**RE: BEK Distribution Facility
601 Gallatin Place NW
Grading and Drainage Plan & Drainage Report
Engineer's Stamp Date: 09/06/19
Hydrology File: J10D002G1**

Based upon the information provided in your resubmittal received 09/06/2019, the Grading & Drainage Plan and Drainage Report are approved for Building Permit, Grading Permit, and for action by the DRB on Site Plan for Building Permit.

RE: **BEK DISTRIBUTION FACILITY – 601 GALLATIN PL. NW
D&D PLAN AND DRAINAGE REPORT ENGINEERS
STAMP DATE 07/19/2019, HYDROLOGY FILE: FJ10D002G1**

STORM SEWER PLAN AND PROFILE

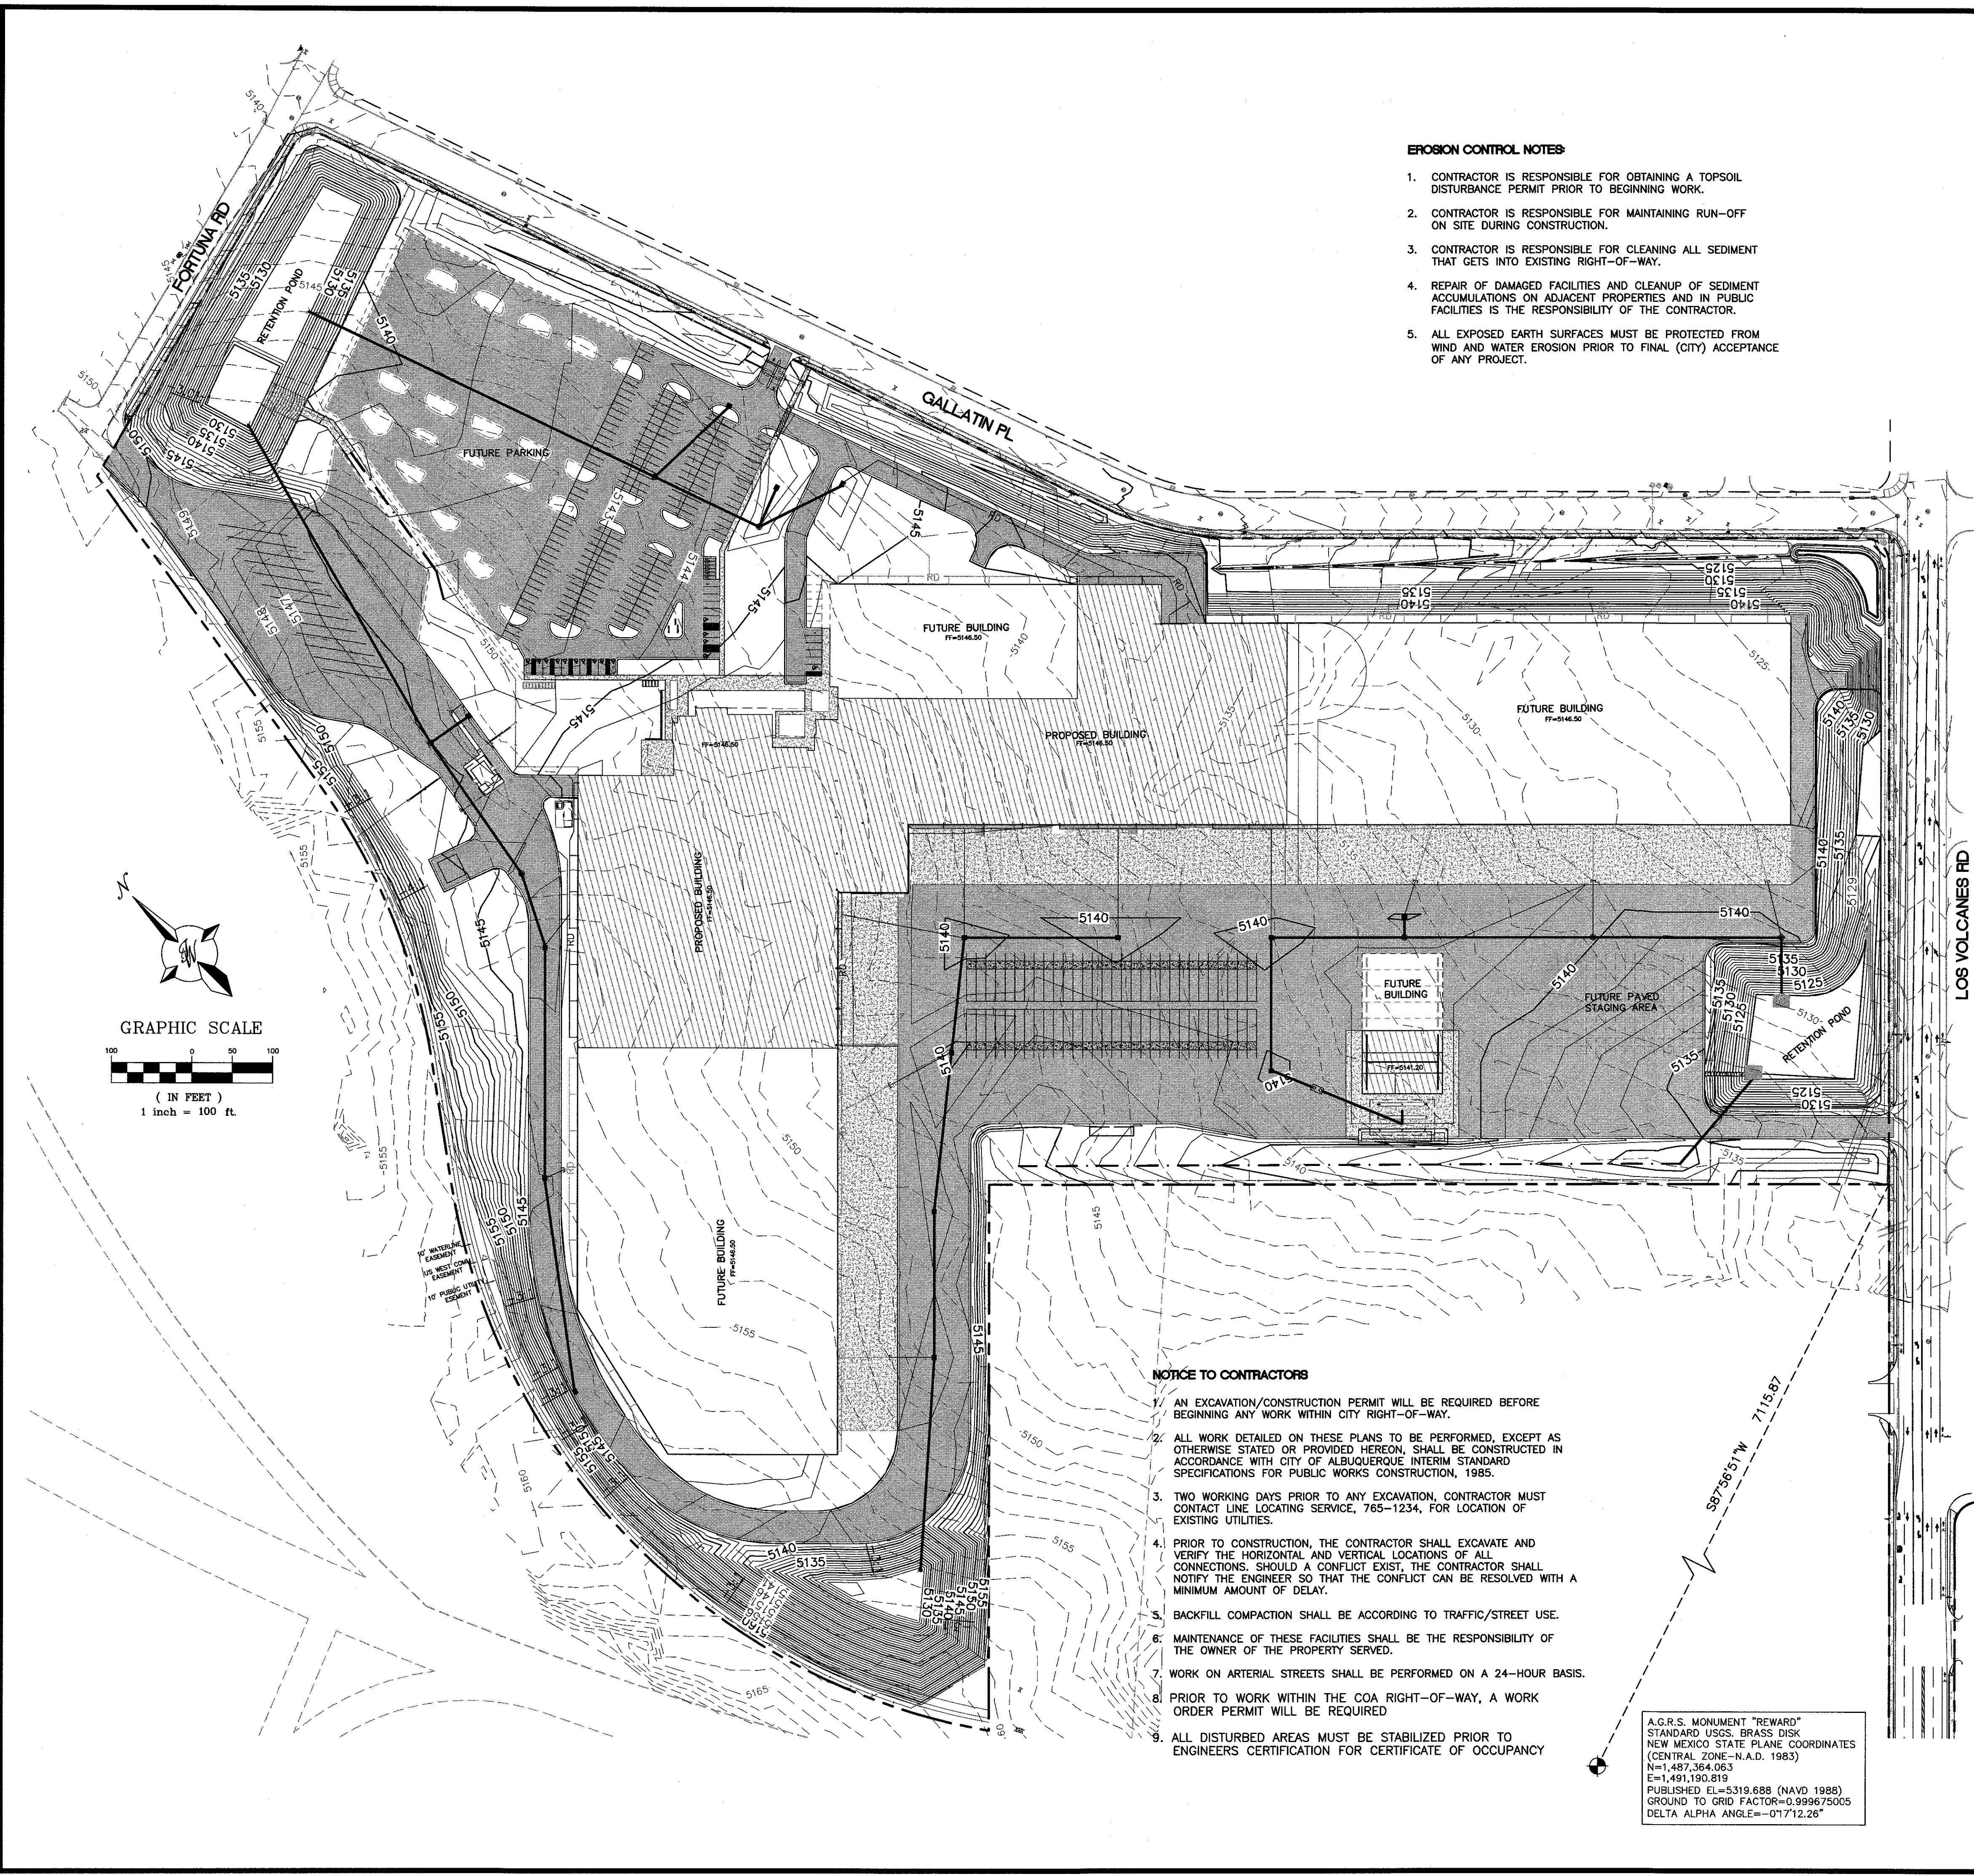
Response: The finish contours were added in the noted area on Sheet C203. Typical sections of this area are shown on Sheet C213, Section G.
11. HGL calculations are required for the storm drain in the north east corner of the site where failure of the storm drain could result in excessive storm water runoff to public streets. Also please add a profile and HGL calculations for the storm drain on the south and east side of the building.

Response: HGL profile and calculations were added to the plan Sheets C206, C210 & C211 and report for the storm drains in the northeast corner of the site and the southeast side of the building.
